Subject: Norfolk Vanguard Sub Station at Necton

The Representation of Little Dunham Parish Council on Landscape Mitigation on The Proposed Vattenfall Substation

Indicative Onshore Project Substation
Mitigation Planting - Norfolk Vanguard

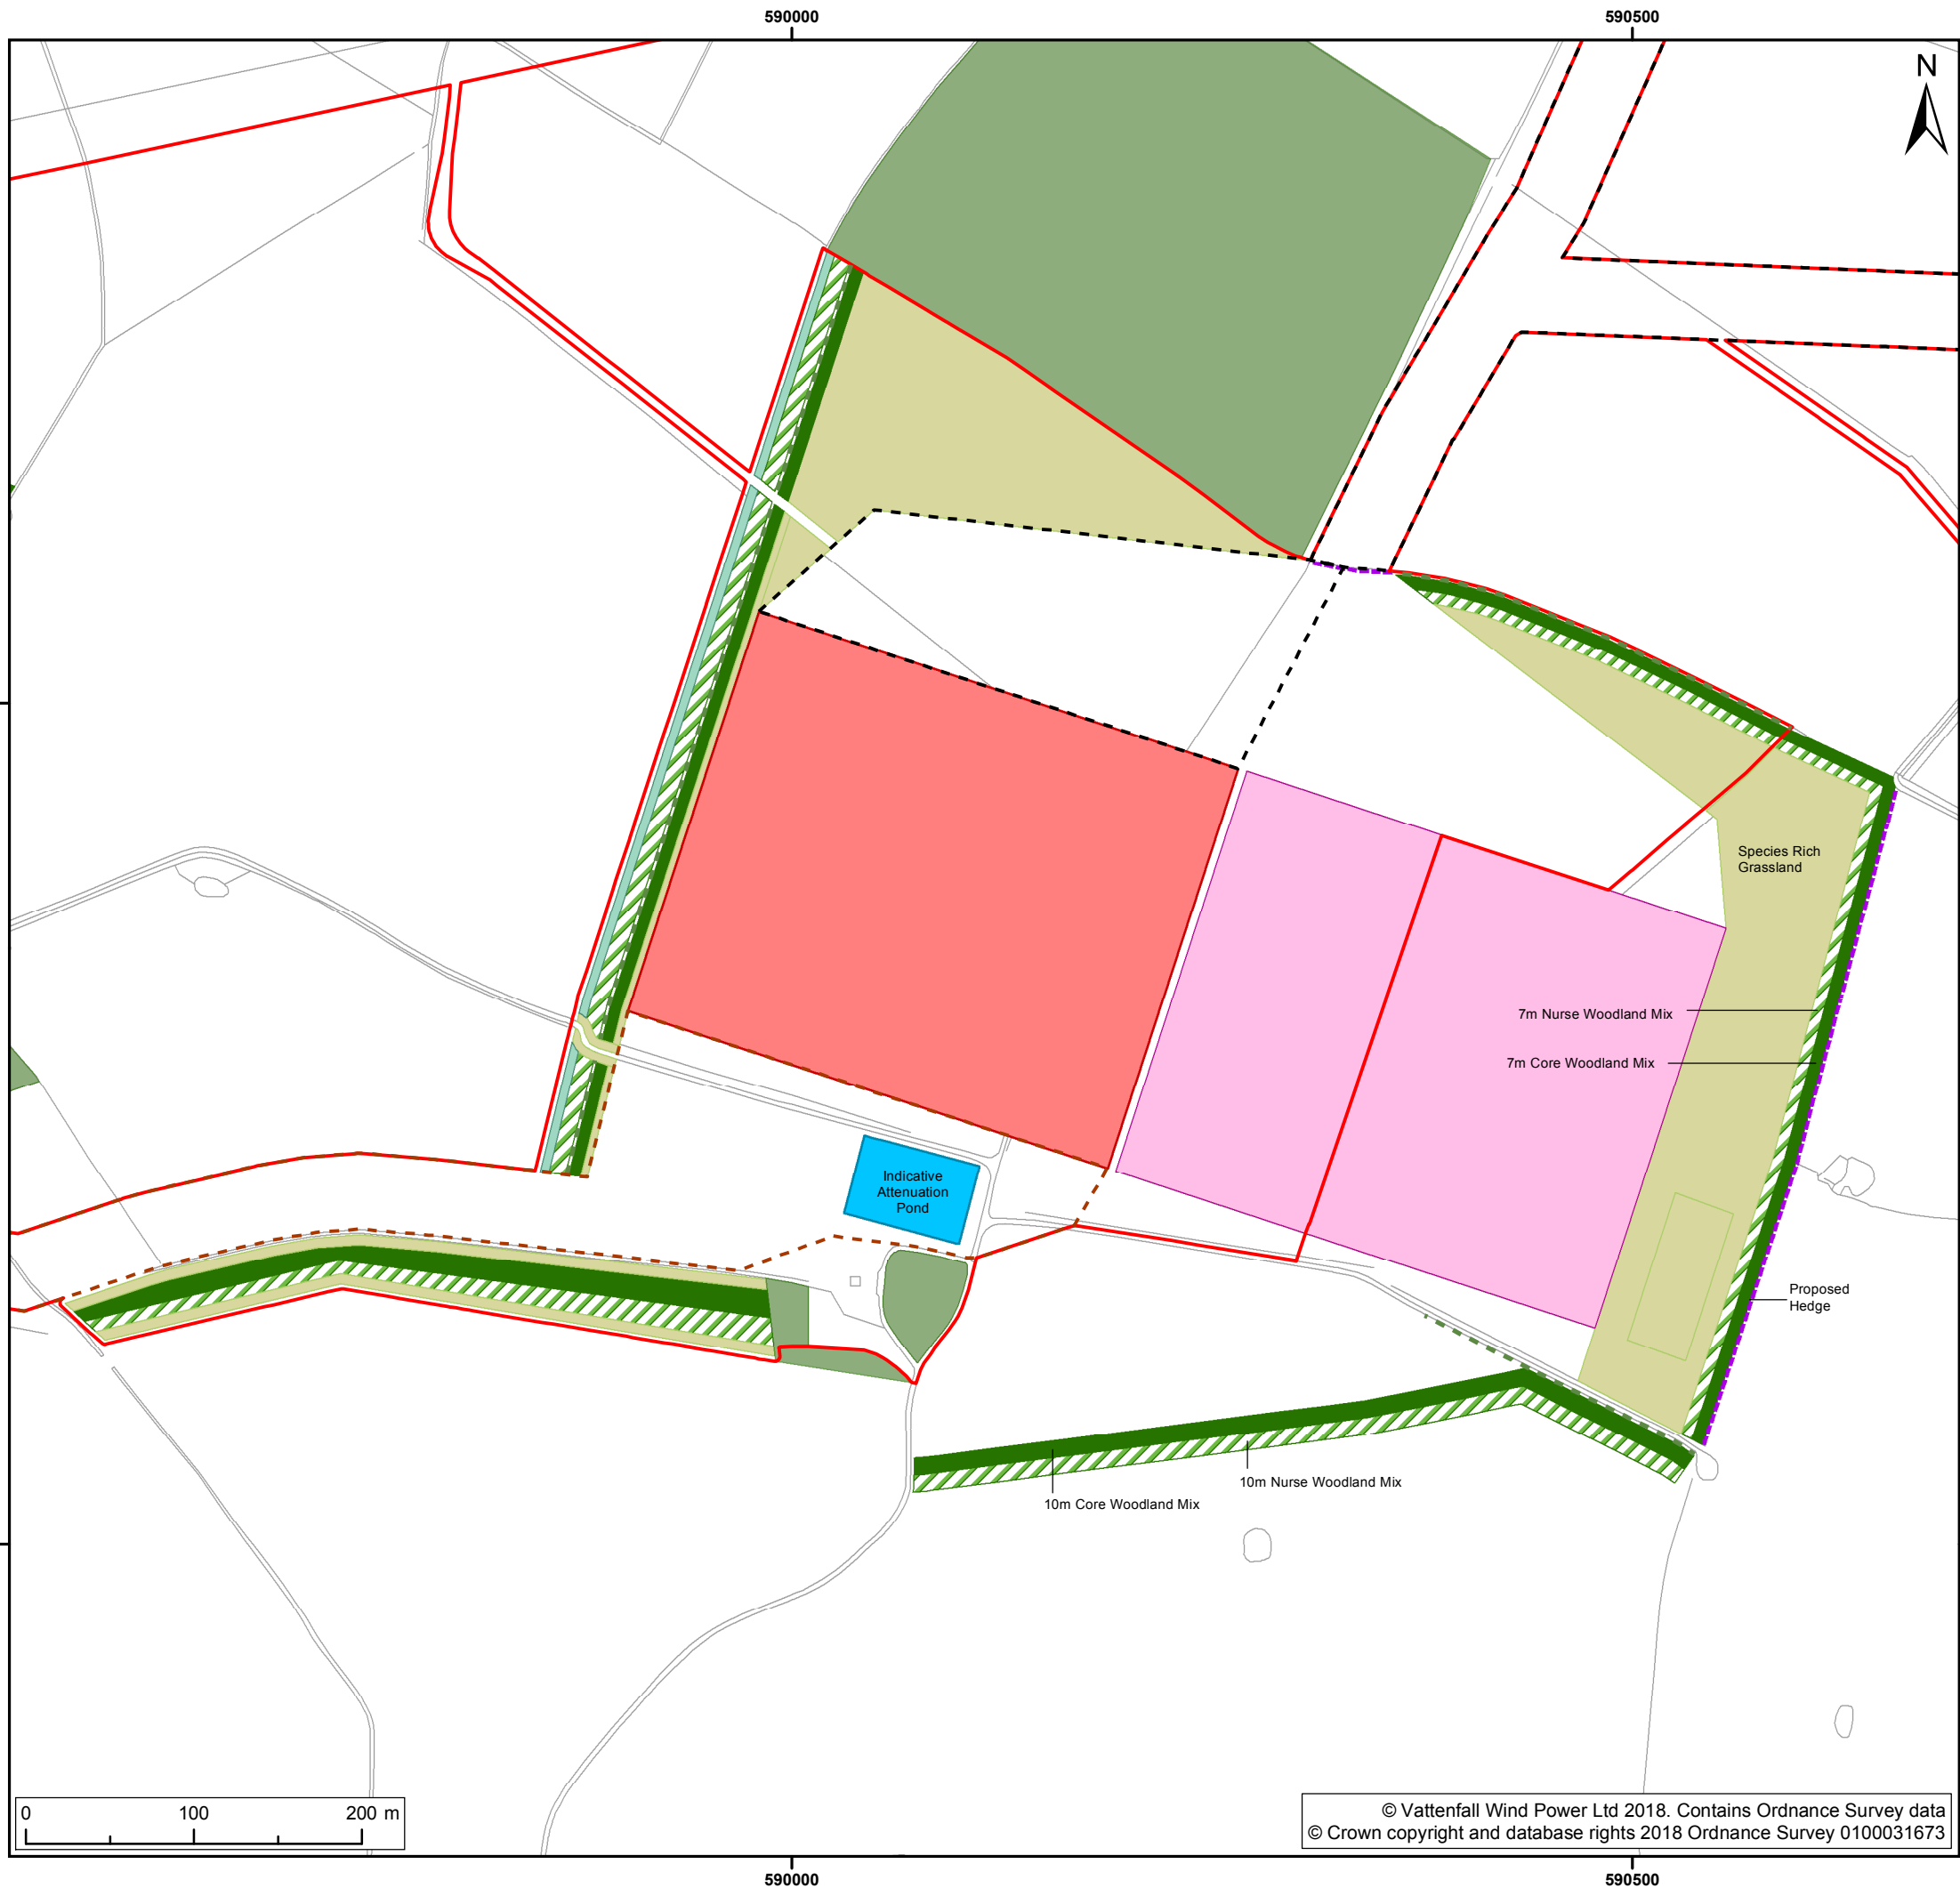
There is a gentle downward slope away from the A47 so that it is extremely difficult to mask the site as it is been looked down on from the road. It has been noted that the area is gently undulating so that to create banks and bunds with steep sides would be out of keeping with the surrounding countryside. The only way to effectively obscure such large structures is to sink the tallest buildings a substantial distance under the existing ground level. This would have the added advantage that the material dug out can be used to create a natural looking bank to the north of the construction site being made sympathetic to the configuration to the surrounding countryside. More soil would be needed on broader gentler slopes than on steeper ones giving a greater reason to sink the buildings even lower. Care would have to be taken to strip the top soil back and kept separate so that it would be available to be reused as top soil on the reconfigured bank.

Local materials used in construction such as brick would help alleviate the visual impact.

It is necessary to have a complete woodland screen on the north side of the site towards the A47. It would not be appropriate to the area to have a single sweep of woodland but to have a more fragmented approach with smaller distinctly shaped woods creating a patchwork of covers.

Mainly 60-80 transplants with up to 50% understorey planting.

Some larger bare root 2m high trees for greater early impact

Some semi mature trees for immediate impact especially along the sides of the enclosed buildings to break up the mass.

To retain the traditional form of management of coppice with standards with predominately oak with a hazel understorey.
